City of Sydney

North West Precinct Redevelopment - Royal Prince Alfred Hospital, 67-73 Missenden Road, Camperdown

I refer to your letter of 16 August 2012 about the Environmental Assessment (EA) submitted for the North West Precinct Redevelopment.

DEPARTMENT OF PLANNING SUBMISSION
LOWER GROUND LEVEL PLAN

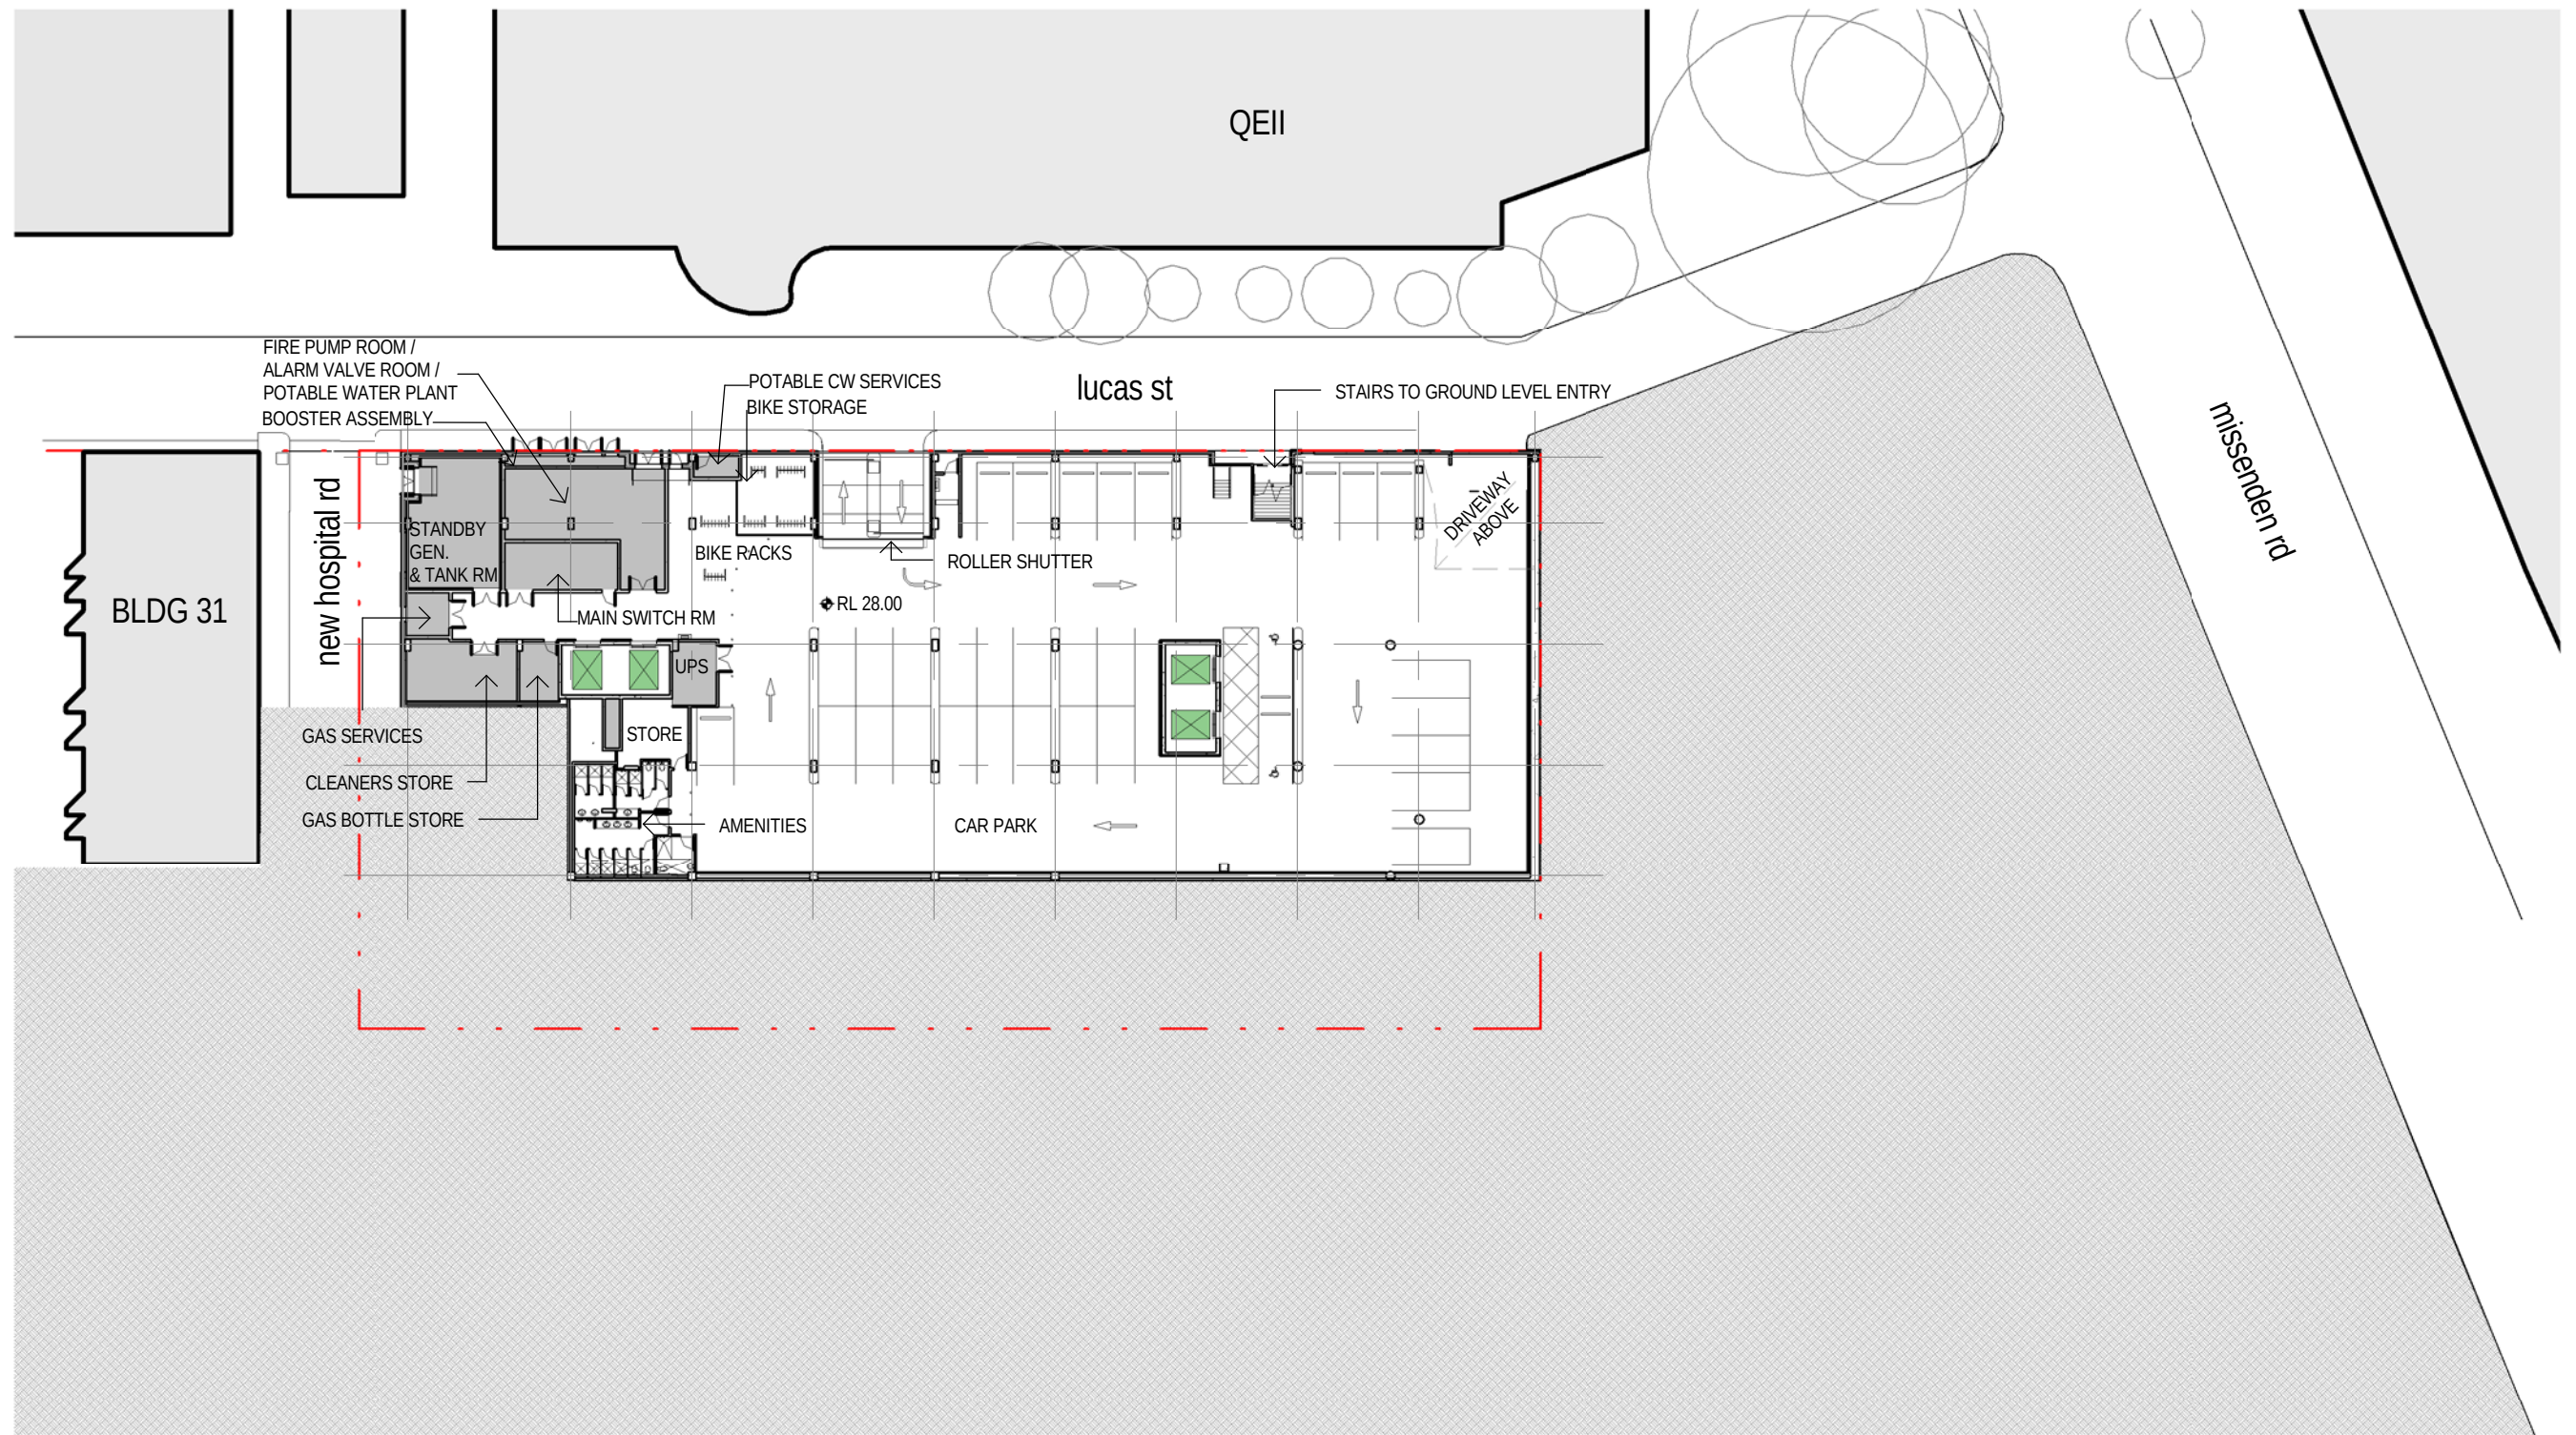
The proposed facade to Lucas Street requires more modulation considering that it currently forms a continuous built 'street wall' of approximately 75-80 metres. Locating the car park on the ground floor further exacerbates the 'defensive' character of this elevation preventing the achievement of a sufficiently activated streetscape. The relationship of solid to void needs to be further explored and implemented.

- (i) Climbers and plantings are proposed along the building frontage to Lucas Street, however no building or basement car park setback has been provided for this landscape area within the private development site boundary.

- (ii) Service doors are also shown to encroach into the public domain of Lucas Street.

GROUND LEVEL PLAN

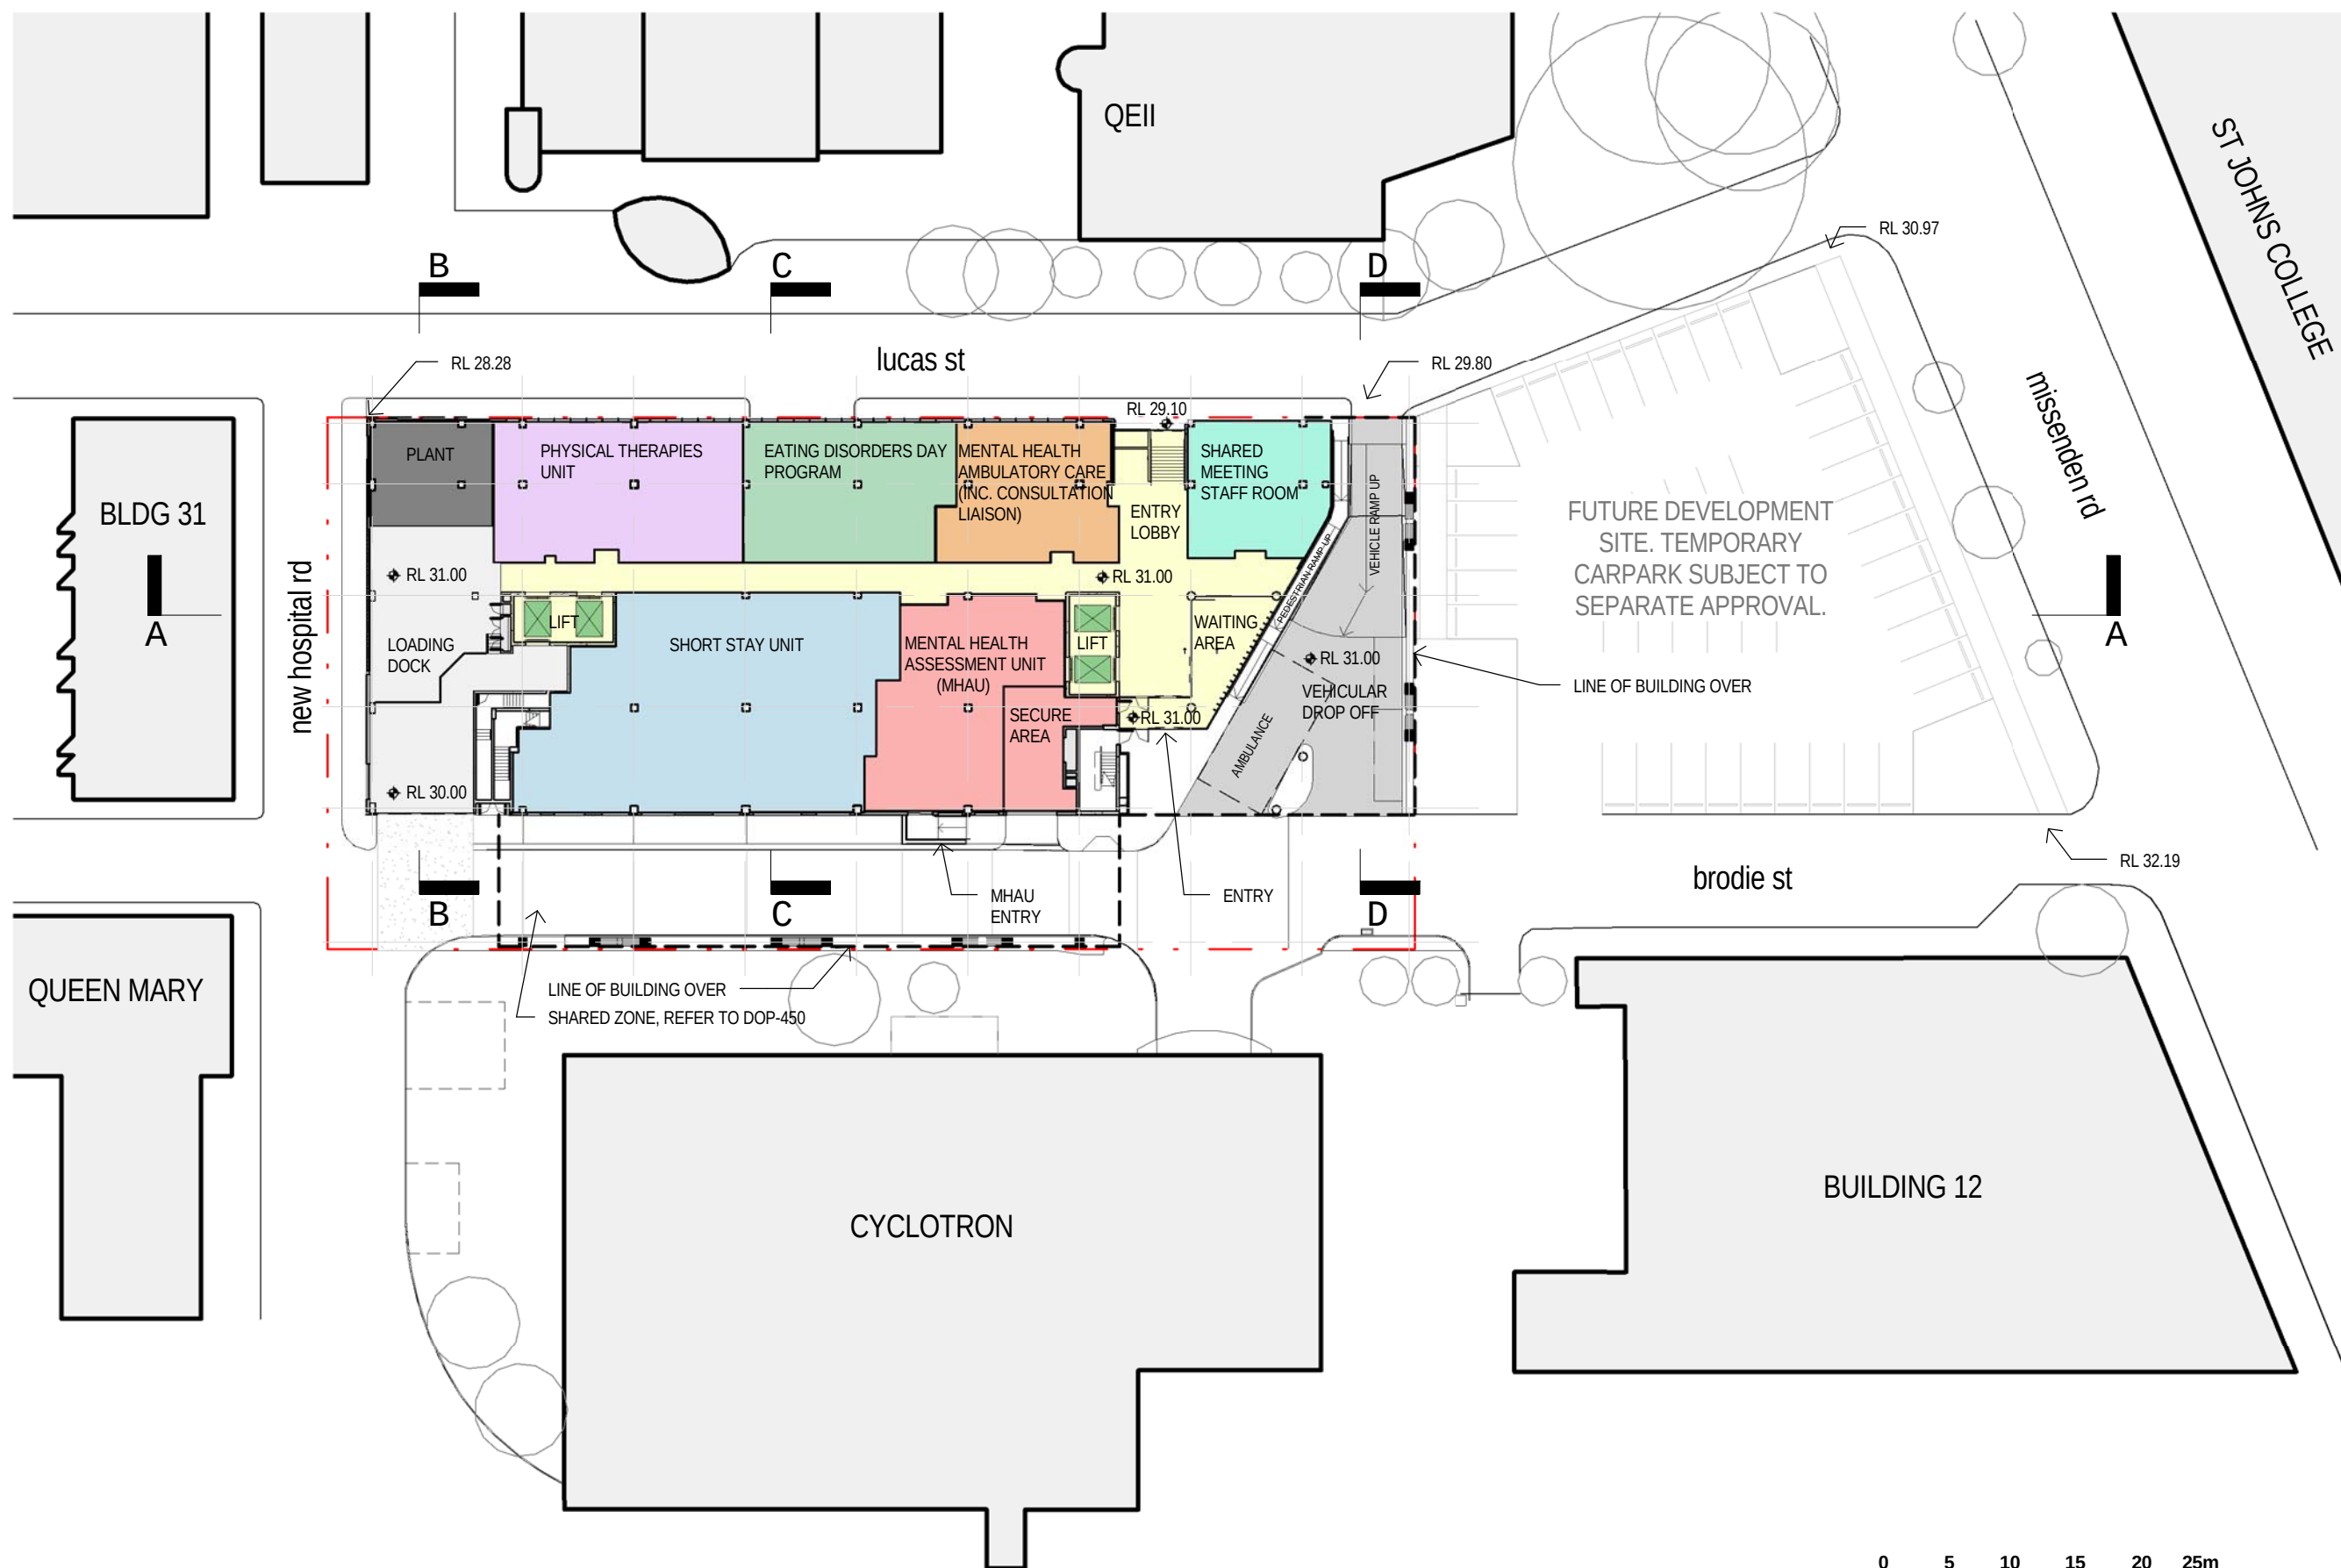
The proposed primary entry is located well within the covered forecourt area at the front of the building, is not clearly identifiable from Lucas Street and may rely too heavily on signage. Improved design and the incorporation of a secondary entry facing Lucas Street will eliminate this issue and improve the activation of the streetscape.

The proposed loading arrangements require manoeuvres that are considered to be unsafe. Specifically, the swept paths show that:

- (i) vehicles entering and exiting the loading area will be required to perform u-turns and reverse through the intersection of Brodie and Hospital Road; and
- (ii) vehicles entering the loading area will also need to reverse through the proposed shared zone on Brodie Street.

Both movements requiring manoeuvring and reversing through an intersection zone and vehicles entering the loading area also need to reverse in to a shared pedestrian zone. Both movements are considered unsuitable for a new development and it is recommended that the loading arrangements be reviewed and redesigned.

Brodie Street is identified as an important pedestrian connection through the site. Concern is raised that the design will create conflict between vehicles and pedestrians resulting in safety issues and it is recommended that the area be redesigned (possibly with a separated footway of sufficient width be provided).
